Addendum No. 1

RE: Contract # C204495

Mecklenburg County (C-5621)

DUAL ROUNDABOUTS NORTH AND SOUTH OF SR-5544 (CATAWBA AVE)
AND US-21 INTERSECTION IN CORNELIUS.

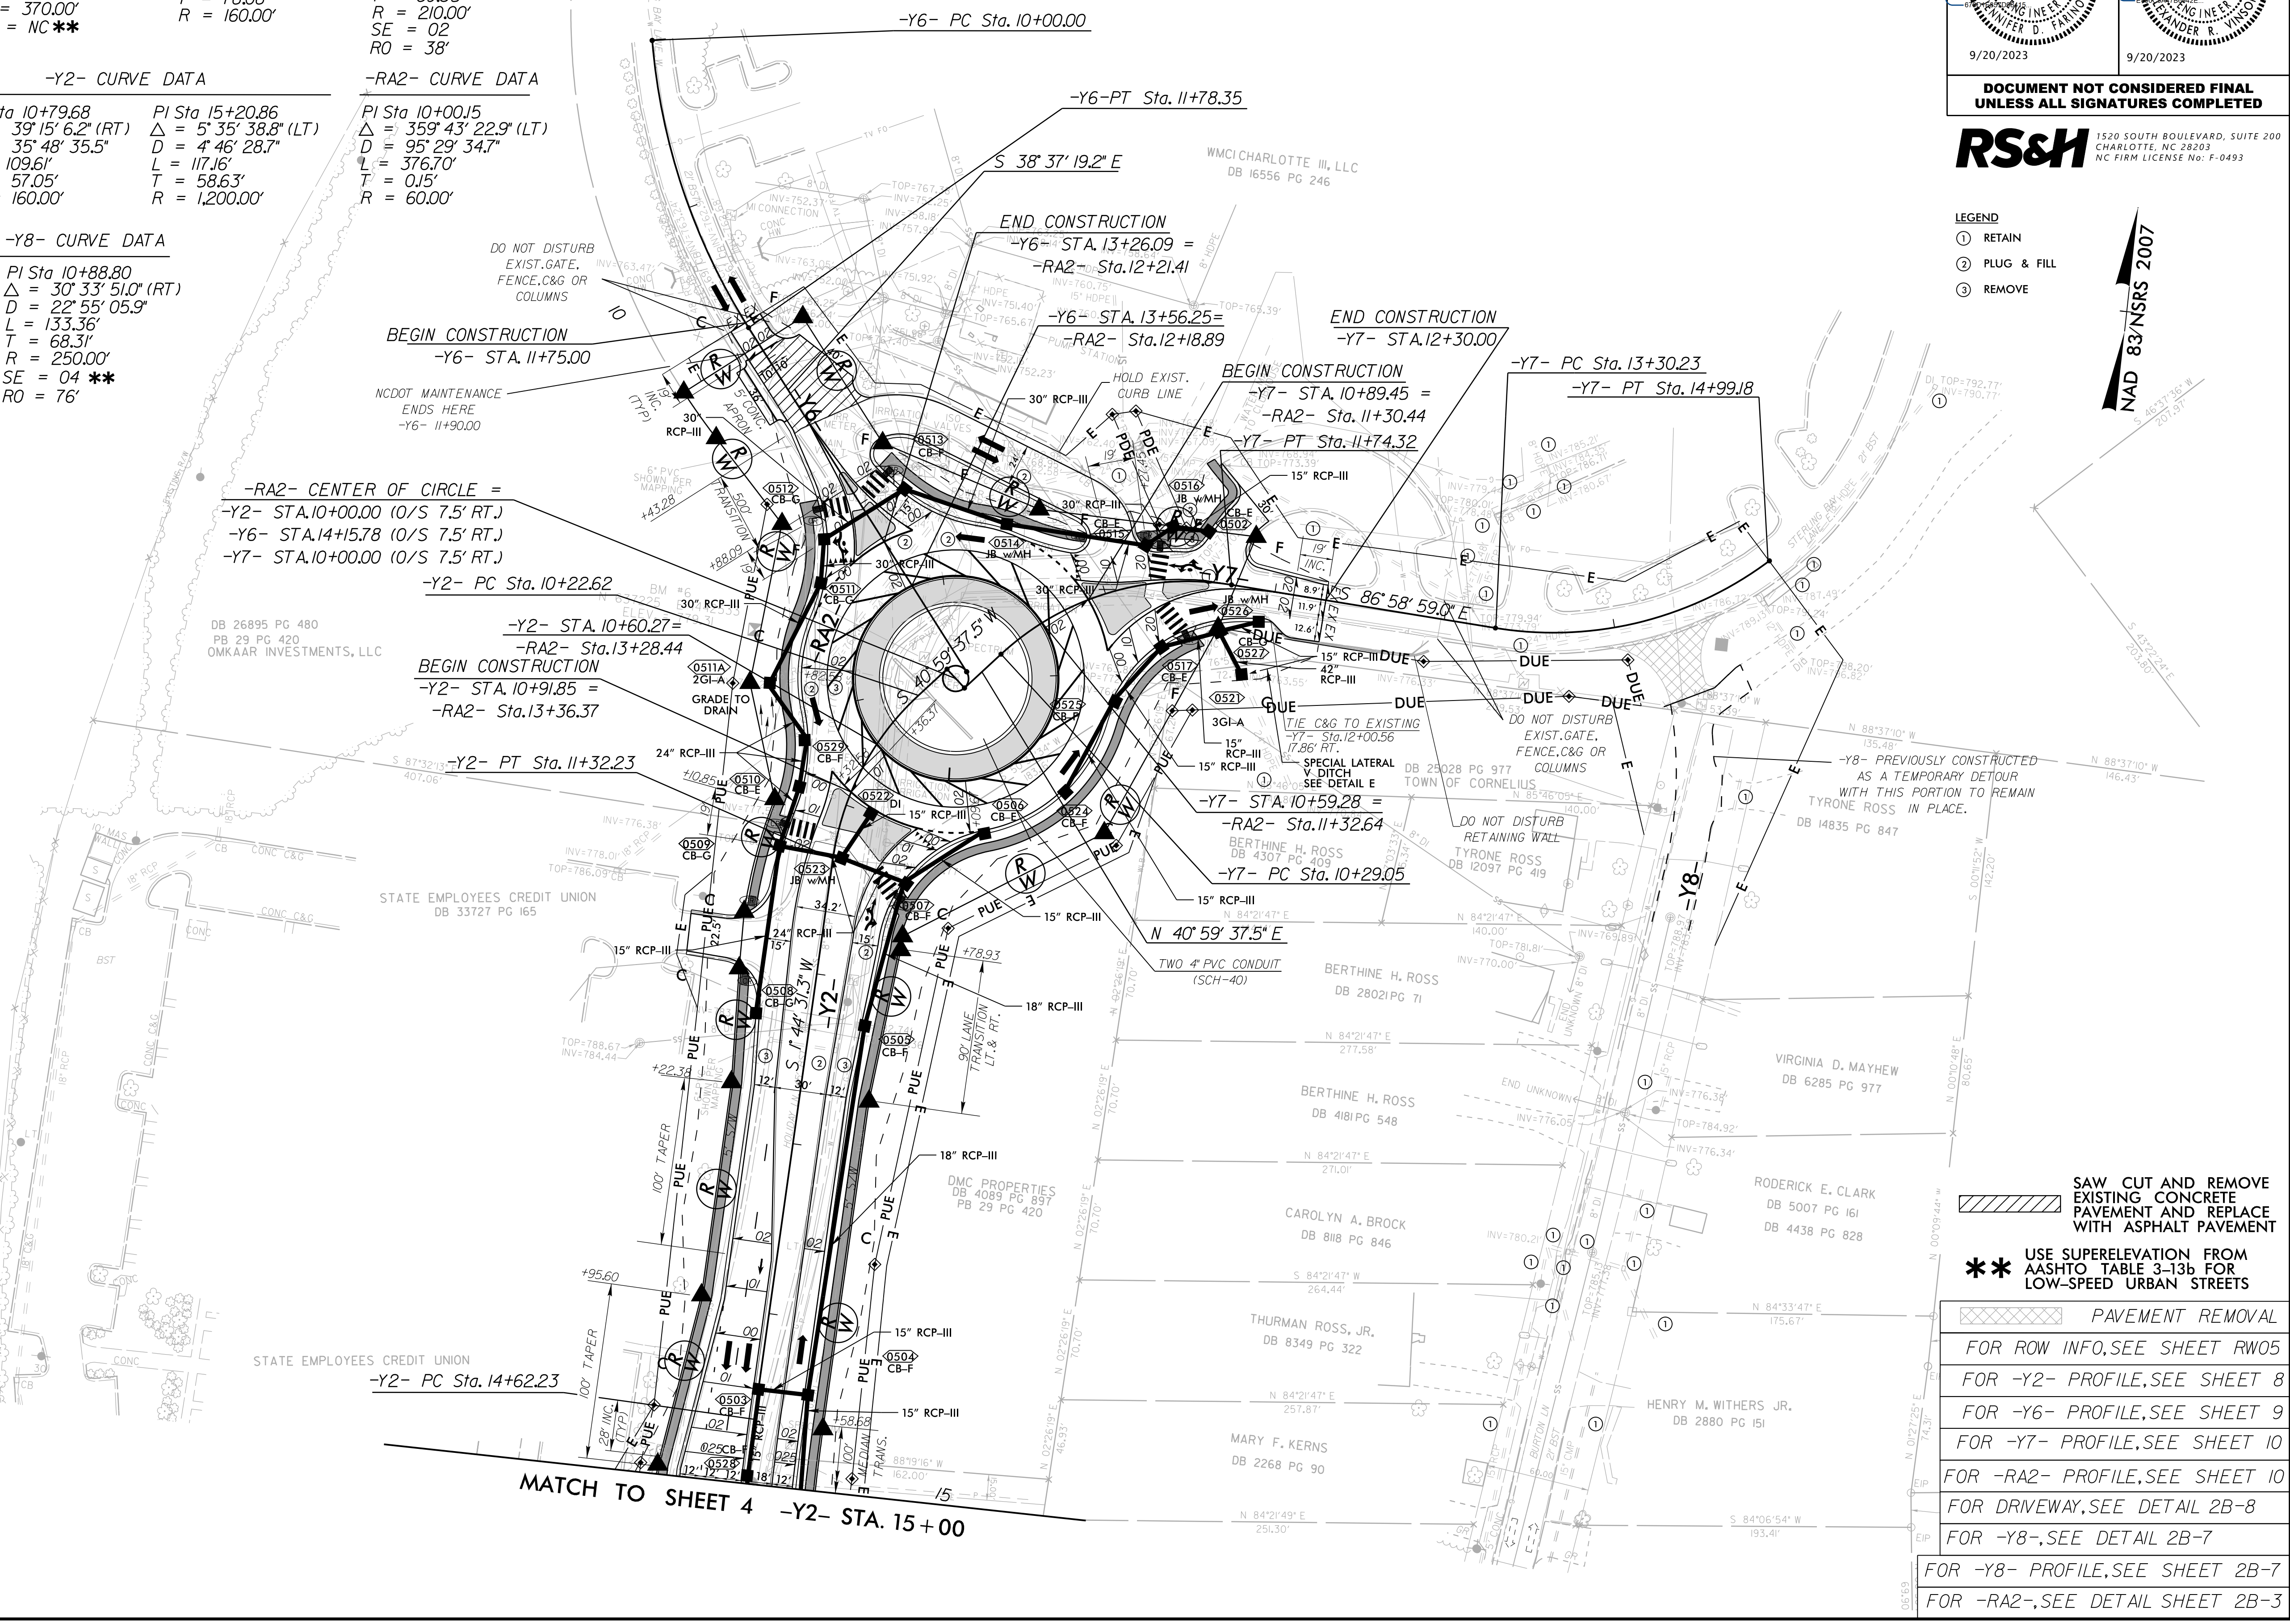
Sheet No.	Revision
1A	Index of Sheets were placed in correct order – Sheets 7 thru 10 Profile sheets moved ahead of the Right of Way sheets.
4	The crosswalk note in the lower right hand corner was removed.
